Subject: Notice of Application SP-20-00004 Hein

RE: SP-20-00004

SUBJECT: Hein Short Plat SP-20-00004

Well location

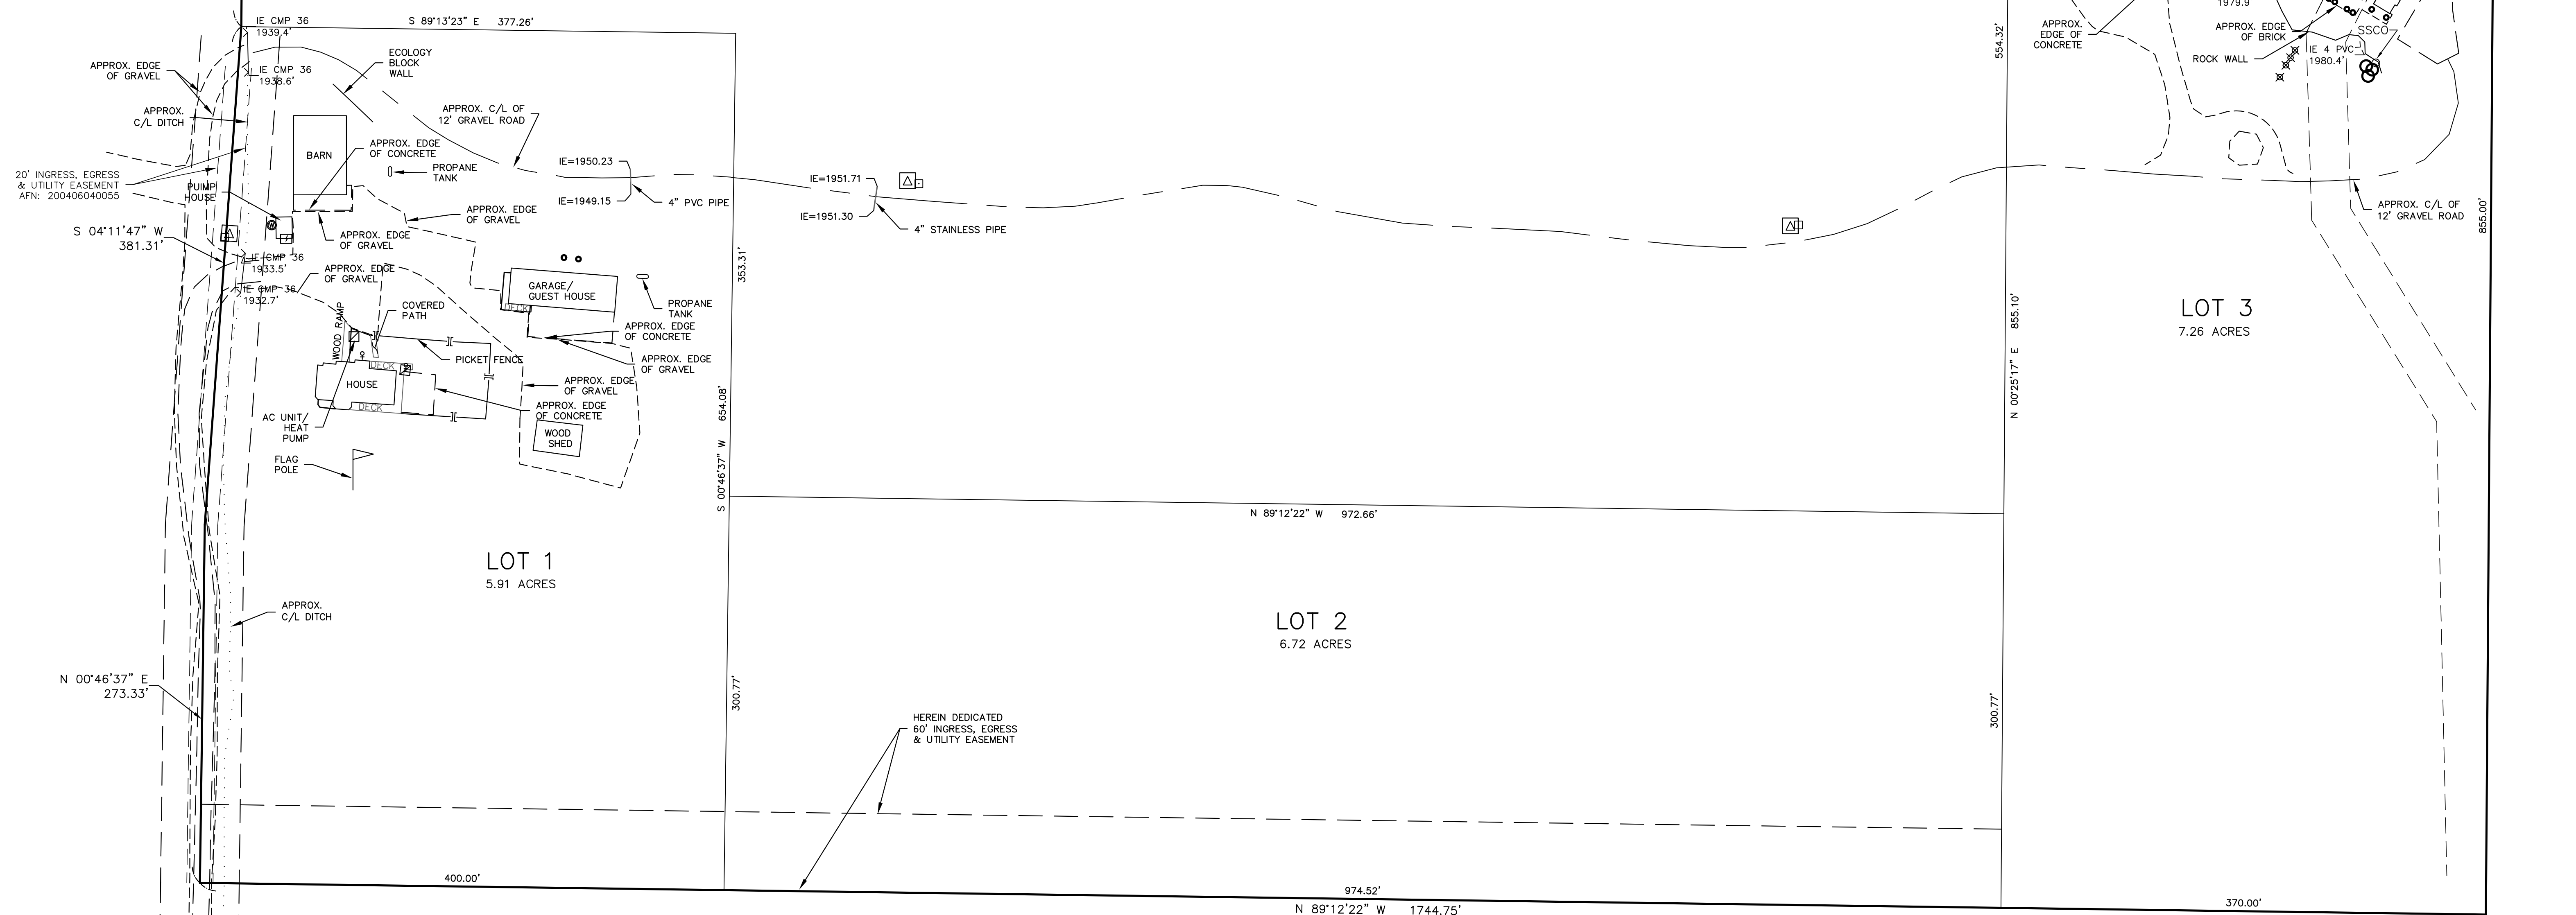
The north property line for lot 3 needs to be relocated to be at least 50 feet from the existing well.

8. Easement Correction: The 30' access & utility easement crossing Lot 3 must be amended so the home does not encroach upon the easement.

Currently it is 33-ft, but we have flexibility to adjust this line or provide a protective buffer easement around it.

AIRPORT ROAD SHORT PLAT APPLICATION

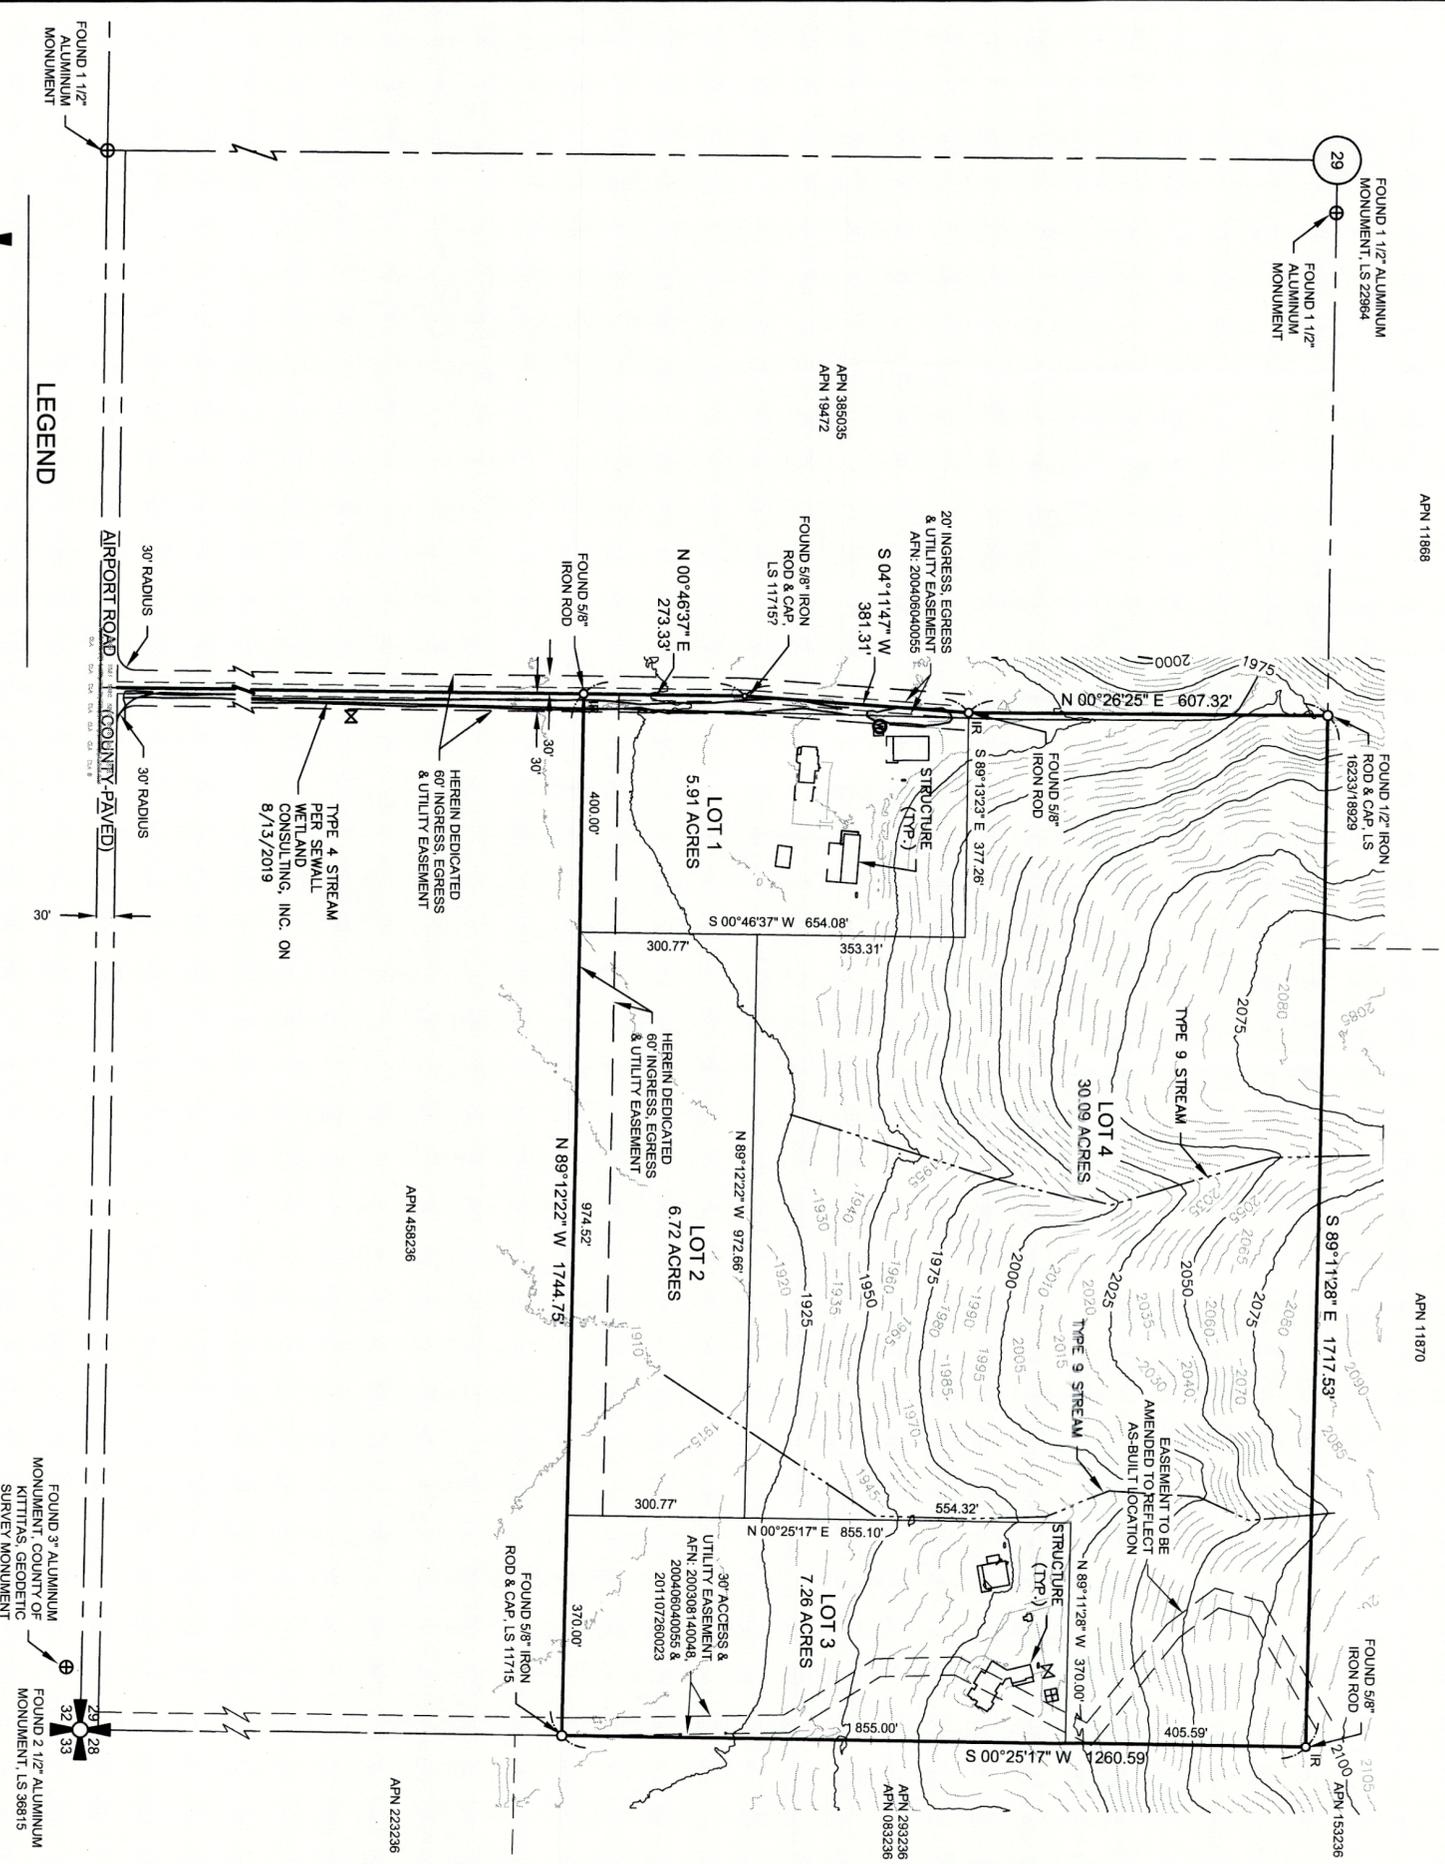
B-2 13.35.020(b) requires proof of adequate water supply, which can be submitted through a well log or 4 hour draw test result. If shared wells are used, a signed, notarized, and recorded shared well-users agreement must be submitted. All individual and shared wells must meet the distance requirement of 50 feet from the property line, 50 feet from the septic tank and 100 feet from the drain field as per Kittitas County Critical Areas Ordinance 17A.08.25, and KCC Chapter 13. Locations of wells on lots 1 and 3 must be provided.

B-3 Soil logs are required for lots 2 and 4. In accordance with KCC 13.04.090, a minimum of one soil log for each proposed lot where individual sewage disposal systems are contemplated must be completed prior to final plat approval. Soil logs can be scheduled at <https://www.co.kittitas.wa.us/health/septic-inspection.aspx>. Soil logs are performed in accordance with Washington Administrative Code 246.272A.

For the proposed lot 3, I am having difficulty determining the location of the well. Can you help with this? This information is needed.
